From: Brian Searle <[REDACTED]>
Sent: 09 February 2022
To: Amber Willard
Subject: Re: FW: LU/371/21/PL

site & block plan tp782/09

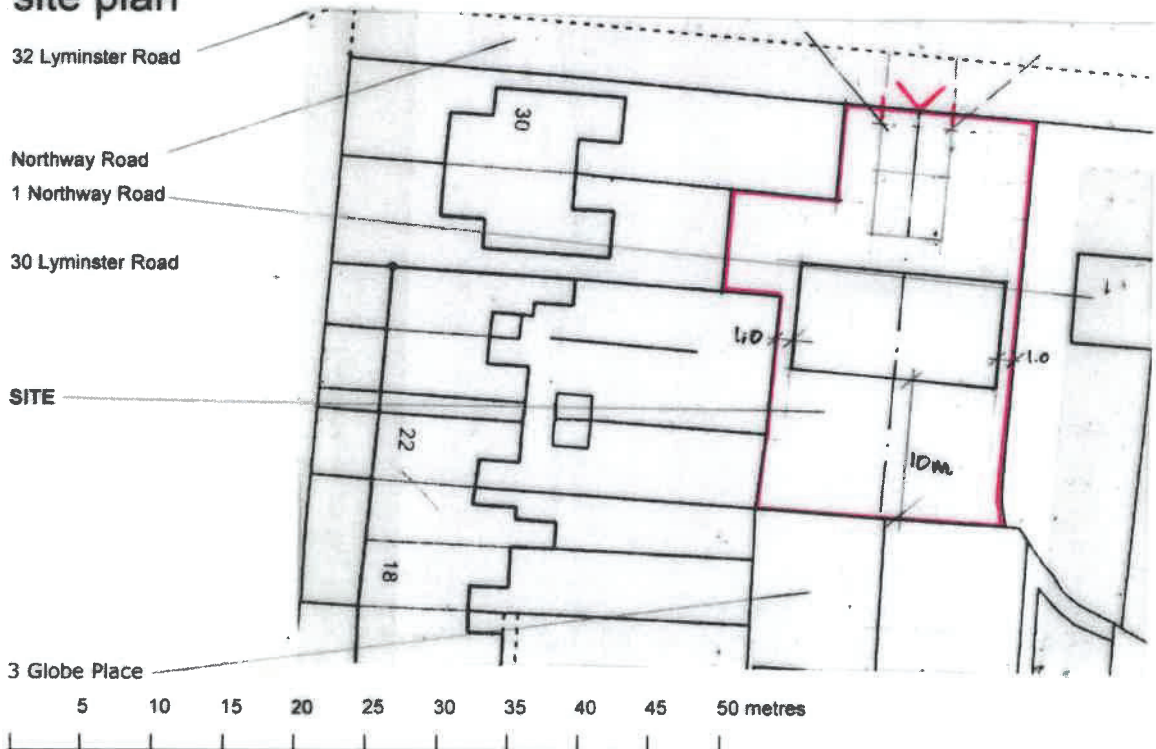
After reading all the documents, and the effort you made to get the site plan from the applicant, it appears that the one you accepted has Northway road outlined in red implying that it is part of the site plan, which as you are aware is not the case.

There also seems to be a discrepancy with the applicant over the size of the plot of approx 4meters.

Has anyone been down to measure the site as we feel that the minimum footprints for the building necessary ,when you take in the triangular area in the south west corner of the plot, that has an existing covenant on it, stating that it cannot be built on does not meet current rules.

With reference to to above application, I am aware that planning permission is already approved, but on inspection of the of the site and block plan drawings there is a clear indication, with the drawing of a red arrow, that the applicant is showing that he assumes access to the land will be via Northway Road
